Thank you for inviting the Lead Local Flood Authority to comment on the below application.

**PLANNING APPLICATION CONSULTATION RESPONSE**

<b>Application Number:</b>	3/2025/0141
<b>Proposal:</b>	Regularisation of erection of three commercial buildings (10 commercial units Use Class E) and associated works.
<b>Location:</b>	Bolton Fold Farm Alston Lane Longridge PR3 3BN

APPENDIX C

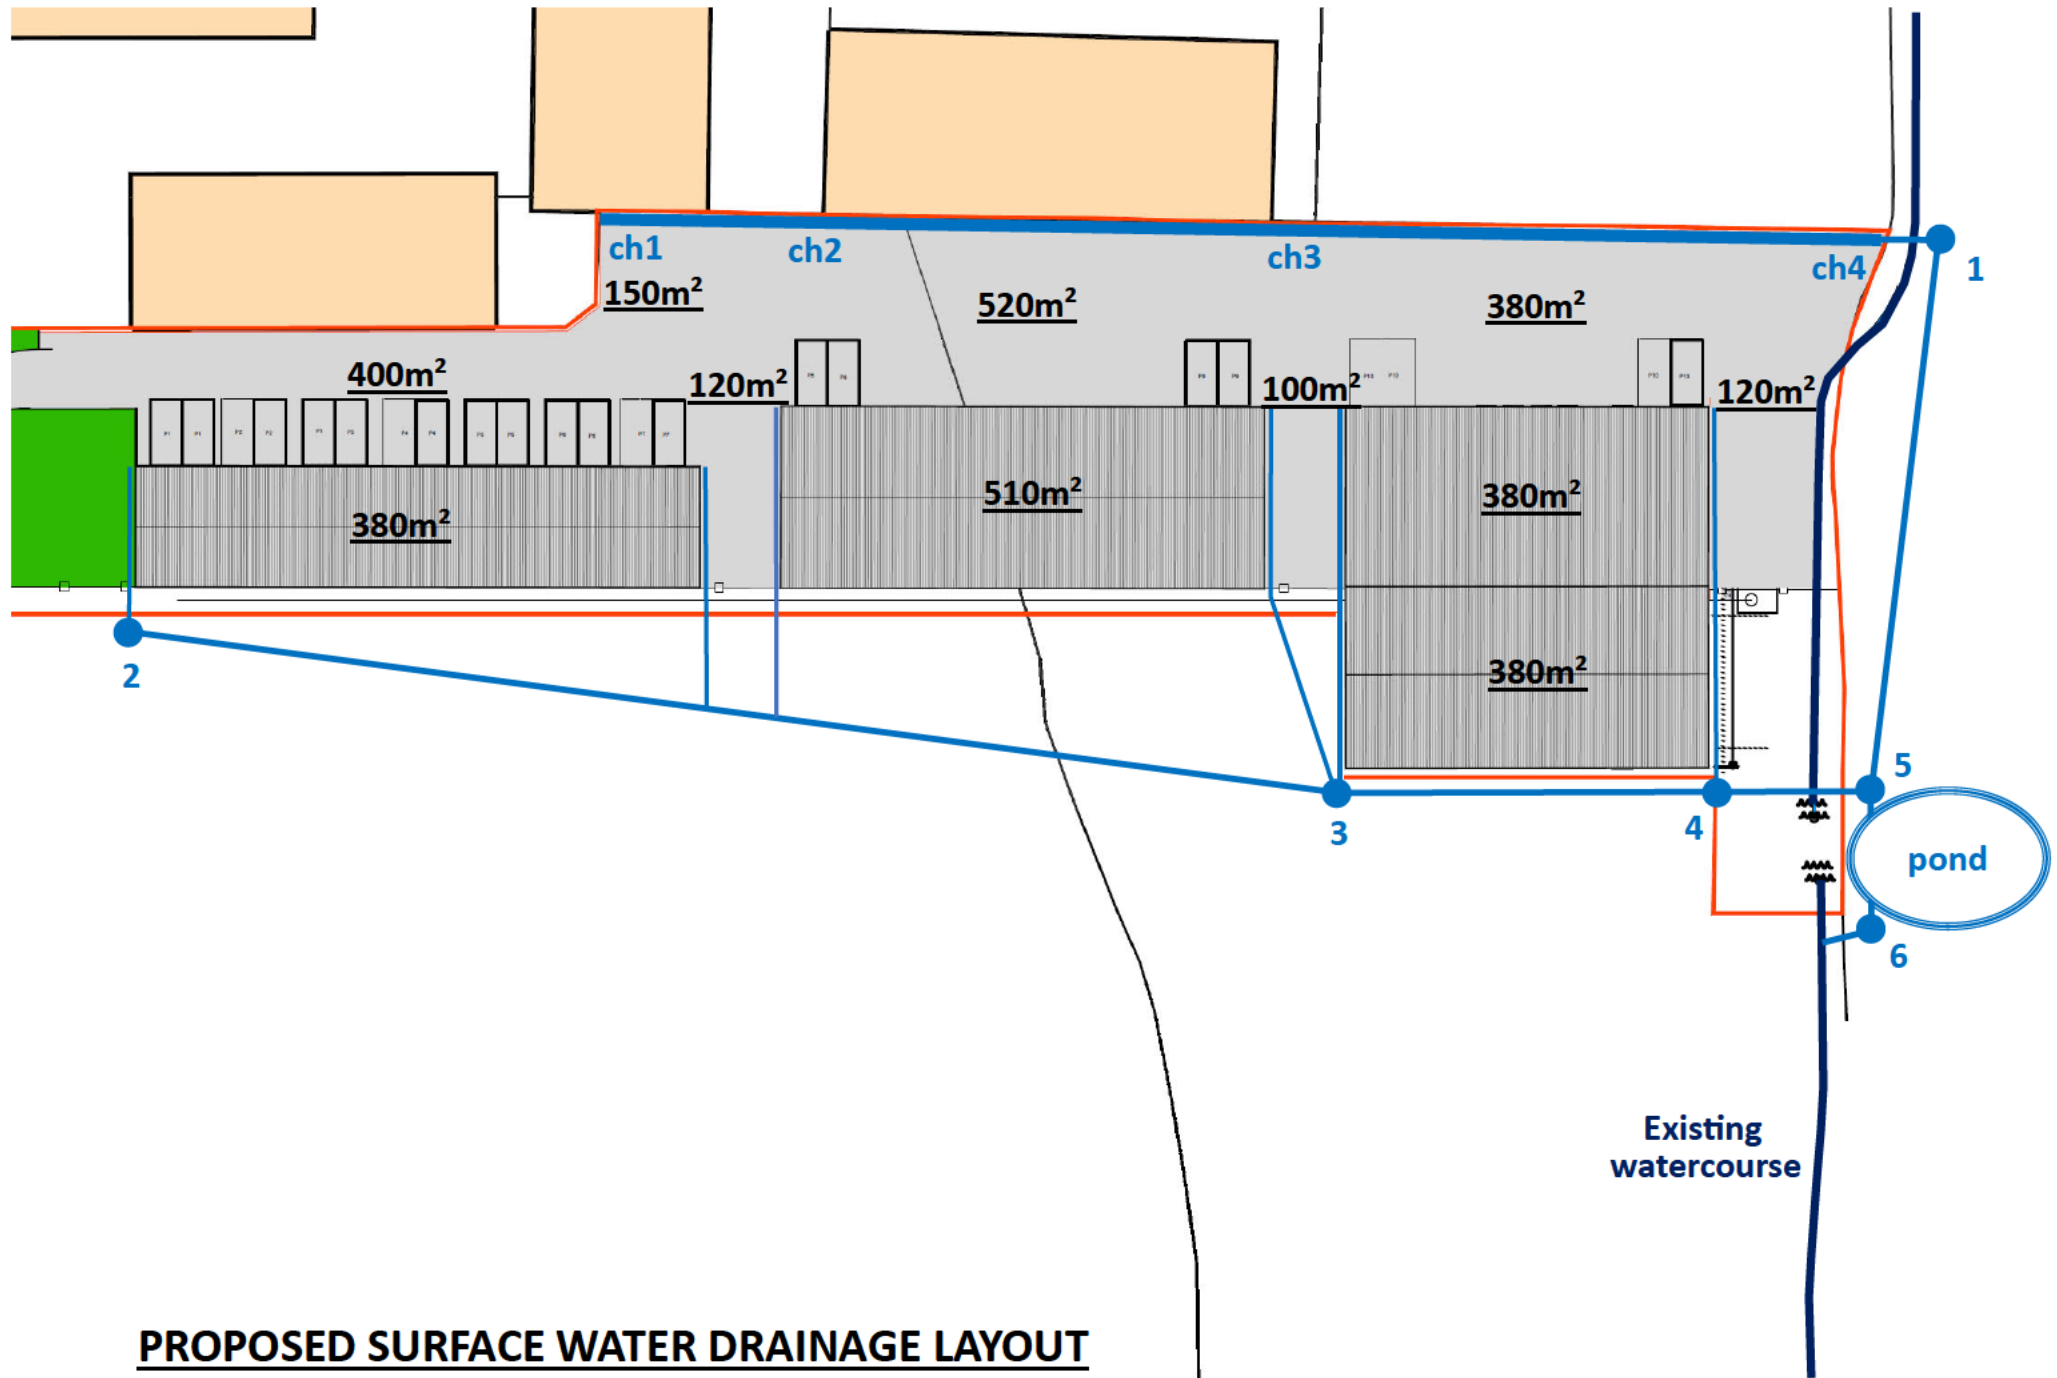
Although the applicant has provided some information as specified in the wording of the condition, the applicant has failed to provide full and detailed information that would be expected at the detailed design stage to ensure that the proposed surface water sustainable drainage system has been designed appropriately. For example, the applicant has failed to take into account the advice provided in our previous response, evidence of an urban creep allowance applied or detailed design evidence of the proposed SuDS Pond and its dimensions, including levels etc or that it has been included in the contributing area plan.

The statement that the watercourse will be taking runoff at a greenfield runoff rate of 2.8l/s is not in itself a demonstration that the proposed watercourse has the sufficient capacity or in sufficient condition to accept flows.
